TOWN AND COUNTRY PLANNING ACT 1990

OUTLINE

Reference:	H23-0707-16	Date of Decision:	13th September 2016
Applicant:	Mr and Mrs R Fenwick Tweenus 17 Cobgate Whaplode Spalding Lincs PE12 6TD		
Location:	Rear: Tweenus 17 Cobgate Whaplode Spalding		
Description:	Residential development - single building plot

Job Ref:	Drawing No.
2980-16.	01.
Date	Drawn
MAY 16.	FLD / GRM.

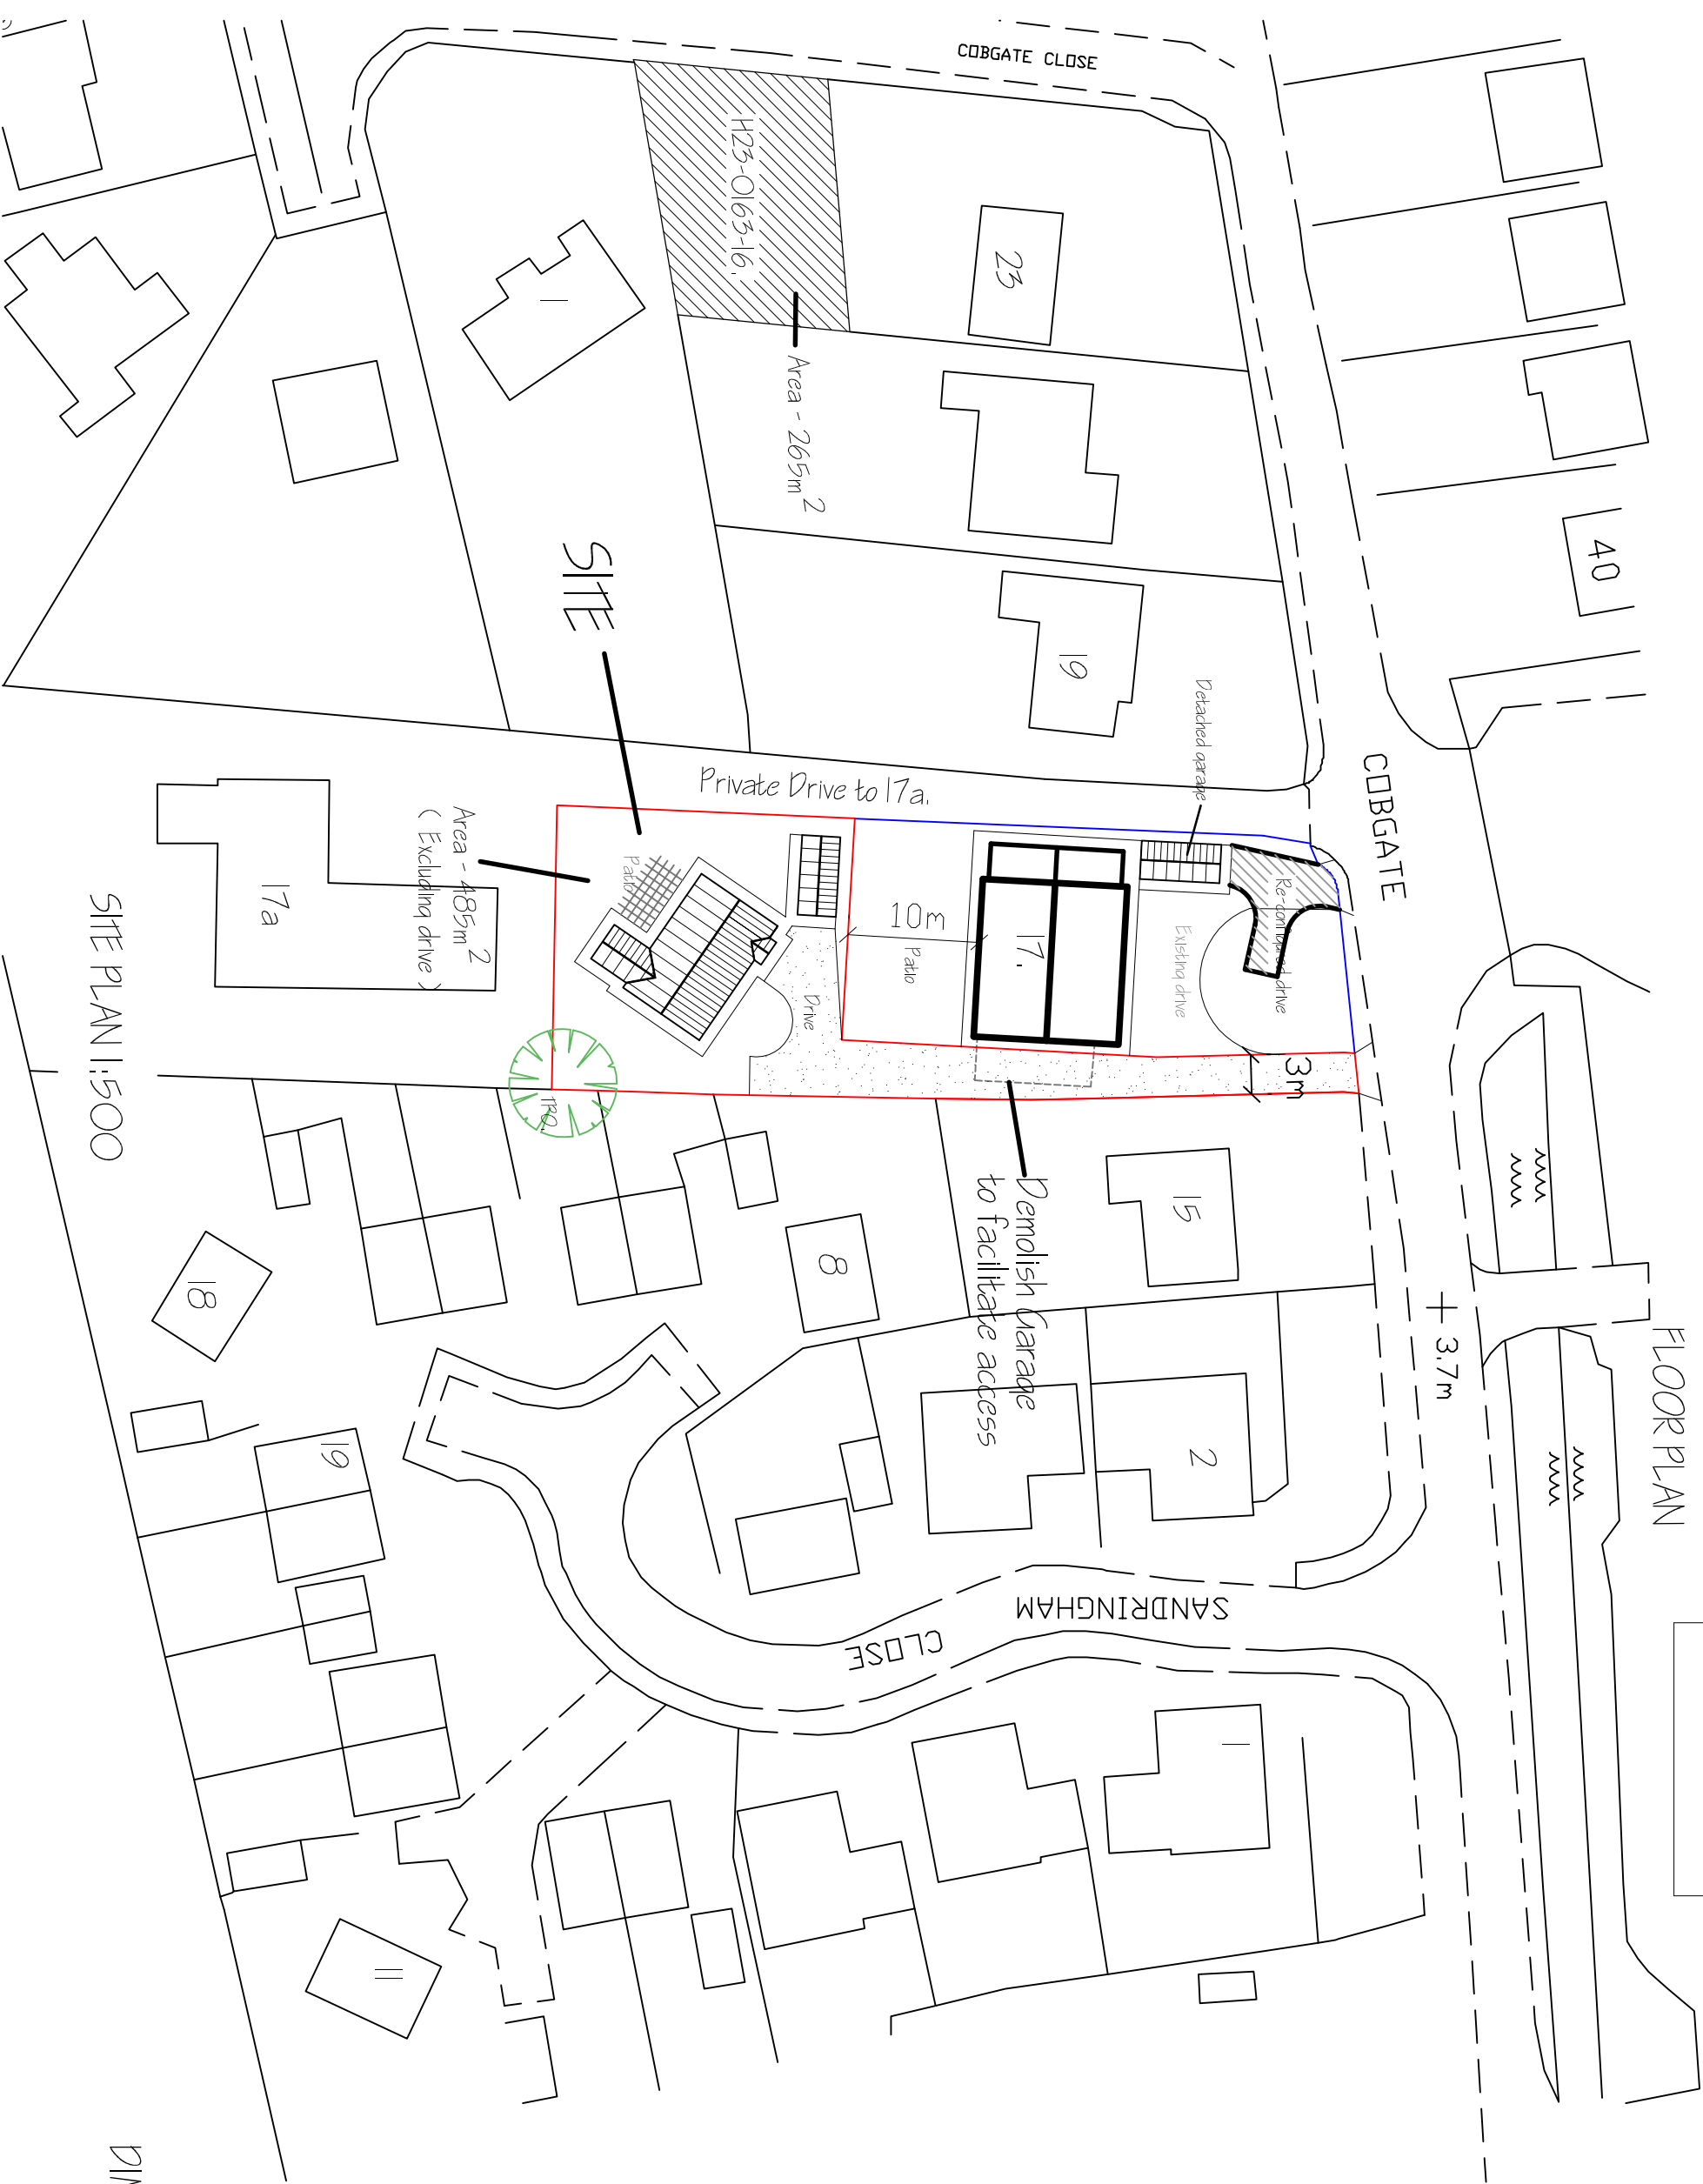
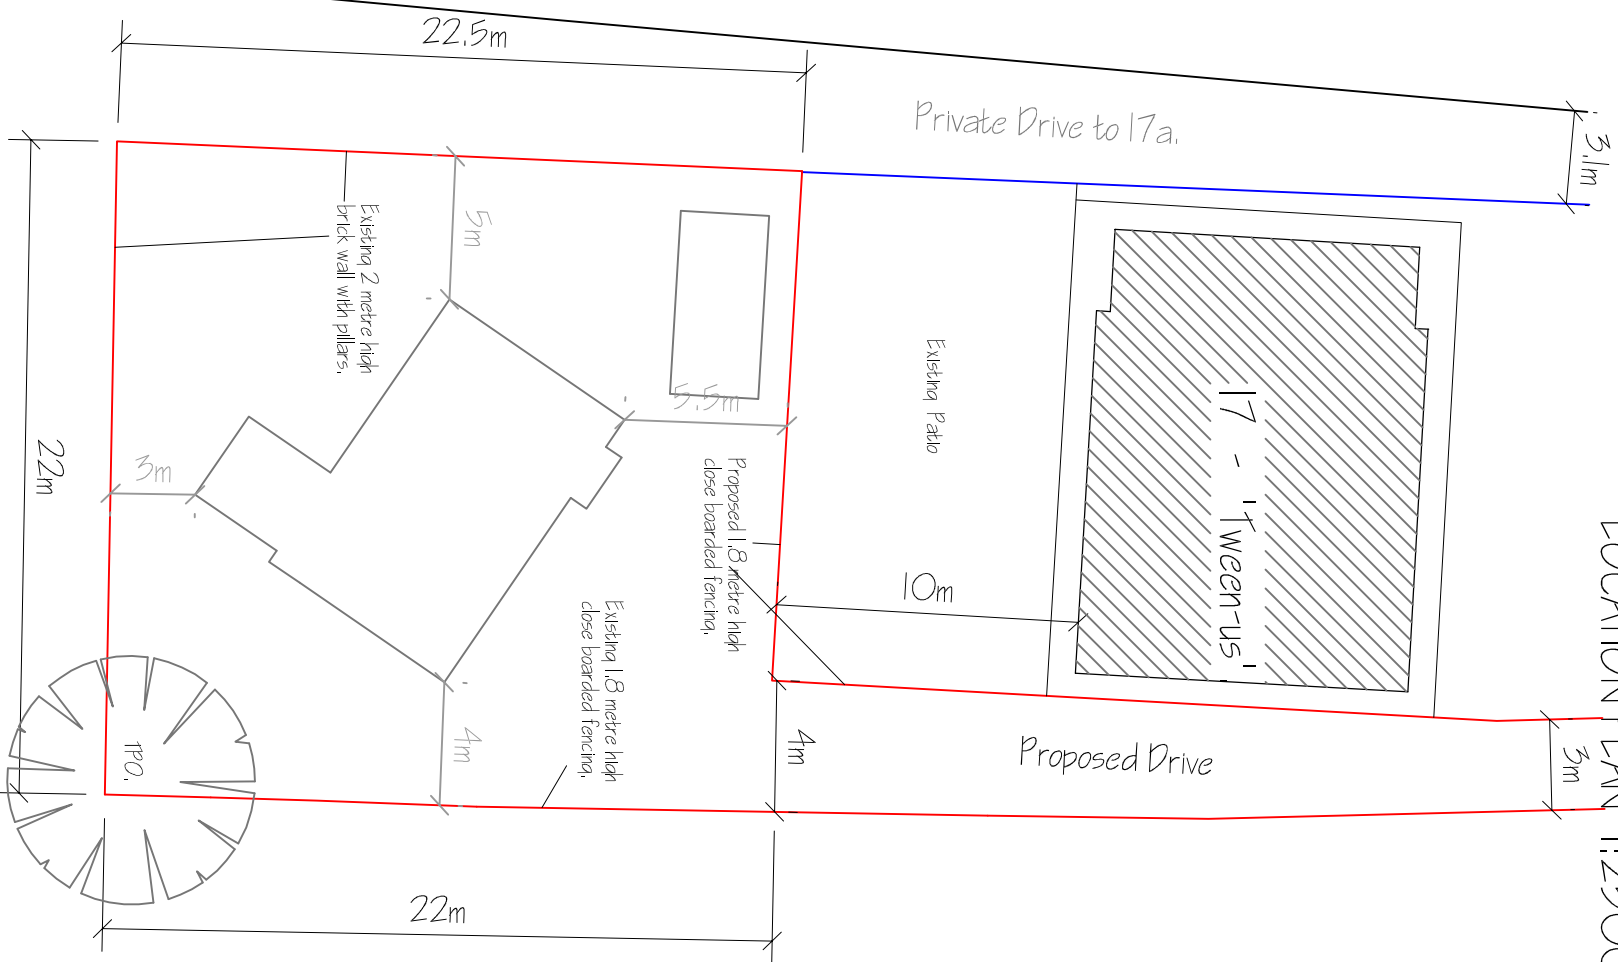
- 1 The site is located on the fringe of the village where existing development is predominantly frontage and is relatively well spaced. The current application, however, is for a backland plot squeezed in between No. 17 Cobgate and No. 17a further to the rear. Such a proposal is considered to be a cramped form of backland development that would be starkly at odds with existing development and harmful to the existing rural character of this part of the village. Accordingly, the proposal would conflict with Local Plan Policy SG14, which indicates that new development should make a positive contribution and not have an adverse effect upon the character and appearance of the locality. It is consistent with paragraphs 53 and 58 of the National Planning Policy Framework, 2012. Paragraph 53 indicates that LPAs should consider the case for setting out policies to resist inappropriate development of residential gardens, for example where development would cause harm to the local area. Para 58 stresses that new development should respond to local character and reflect the identity of its surroundings.

Moreover, the site is located immediately to the rear of existing dwellings, with vehicular access between and in close proximity to no's 15 and 17 Cobgate. It is the opinion of the

Local Planning Authority that the proposed development, by virtue of the restricted size of the plot and its proximity to adjacent dwellings, is a form of backland development that would give rise to increased levels of noise and disturbance to nearby residents. This would arise both from general activities upon the site and associated vehicles entering and leaving the site.

In the context of the foregoing, the proposed development would have a material affect upon the amenity of nearby residents, contrary to the clear objectives of Policies SG14 and SG17 of the South Holland Local Plan, 2006. These policies indicate, inter alia, that new development should not be granted if it would cause material harm to residential amenity.
